From: webmaster@ribblevalley.gov.uk
Sent: 17 January 2021 15:36
To: Planning
Subject: Form completion: Planning Application Comments Form

title: [REDACTED]
LastName: [REDACTED]
firstName: [REDACTED]
numberName: [REDACTED]
postAddress: [REDACTED]
postCode: BB12 7RH
refNo: 3/2021/0011
addDev: Land between 34-40 George Lane Read BB12 7RH

Planning Application 3/2021/0011 Land between 34-40 George Lane I wish to OBJECT to the above planning application as it has significantly changed since the outline planning application (3/2019/0927) was approved with conditions 21/02/2020. The site now breaches the village boundary line and enters into Hammond Ground, which I am sure you know has a long planning history attached to it. A precedent should not be set regarding infringement of these newly adopted boundary lines for the sake of extra garden. The officer reports on the approved outline plan made note of how special attention should be given to the boundary of Hammond Ground. The rear of this site juts out from all the other properties along George Lane for no apparent reason other than exreto adapt to the new orientation & site of the house, which will now have numerous windows overlook

sheet: os plan

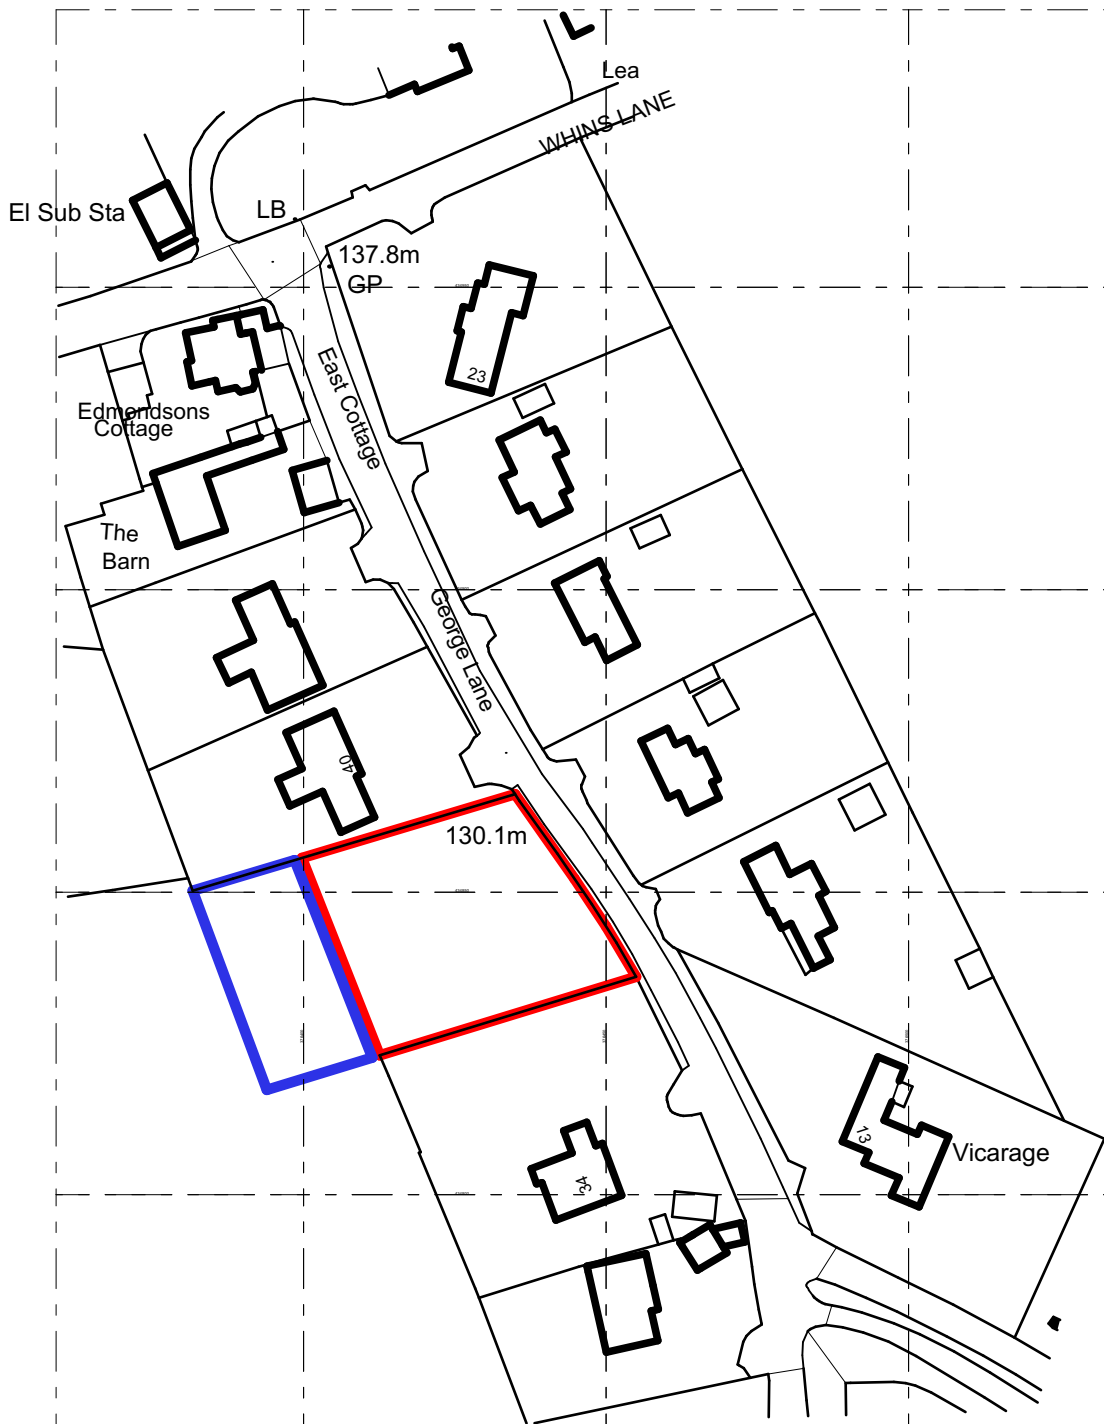
comments: The area of the site plan on this application is not the same as the smaller proposal site plan which is a condition of the permission granted on application 3/2019/0927. The site area has now reverted back to the larger site plan on the original application. There are two issues with this. 1. The site area now clearly juts out beyond the settlement boundary into Hammond Ground as defined by the proposals map for the Districtwide Local Plan. The Districtwide Local Plan draws a straight line between the rear boundaries of numbers 34 and 40. 2. Because of the increased depth of the site, the house sits further back from George Lane and is much larger in size. It also differs in orientation to 3/2019/0927 and has a first floor balcony view across the rear gardens of 34,32 and possibly 30, which was not on the outline planning permission which affects the privacy of the neighbours. It is in line with the rear elevation of number 40 George Lane but is beyond the rear of number 34 allowing this view. This could be simply remedied by pushing the house towards George Lane. Other issues are:- 1. The proposed site plan appears to be wrong. The trees on the left hand side of the plan are actually within 34 George Lane. The description says "existing planted border". This doesn't exist. There is nothing in the brief Design Statement mentioning any planting scheme and the trees on the plan are not as plentiful as the drawn up on this site plan. There is a clear view across the rear gardens of the neighbouring properties. 2. The Design Statement mentions submission to Burnley Borough Council which suggests that this was drawn up quickly and not checked. 2. There is no description of how the rear boundary of the site will be landscaped with Hammond Ground as requested in point 3 of the grant of the outline planning permission in 3/2019/0927

The area of the site plan on this application is not the same as the smaller proposal site plan which is a condition of the permission granted on application 3/2019/027. The site area has now reverted back to the larger site plan on the original application. There are two issues with this. 1. The site area now clearly juts out beyond the settlement boundary into Hammond Ground as defined by the proposals map for the Districtwide Local Plan. The Districtwide Local Plan draws a straight line between the rear boundaries of numbers 34 and 40. 2. Because of the increased depth of the site, the house sits further back from George Lane and is much larger in size. It also differs in orientation to 3/2019/027 and has a first floor balcony view across the rear gardens of 34,32 and possibly 30, which was not on the outline planning permission which affects the privacy of the neighbours. It is in line with the rear elevation of number 40 George Lane but is beyond the rear of number 34 allowing this view. This could be simply remedied by pushing the house towards George Lane. Other issues are:- 1. The proposed site plan appears to be wrong. The trees on the left hand side of the plan are actually within 34 George Lane. The description says "existing planted border". This doesn't exist. There is nothing in the brief Design Statement mentioning any planting scheme and the trees on the plan are not as plentiful as the drawn up on this site plan. There is a clear view across the rear gardens of the neighbouring properties. 2. The Design Statement mentions submission to Burnley Borough Council which suggests that this was drawn up quickly and not checked. 2. There is no description of how the rear boundary of the site will be landscaped with Hammond Ground as requested in point 3 of the grant of the outline planning permission in 3/2019/027.
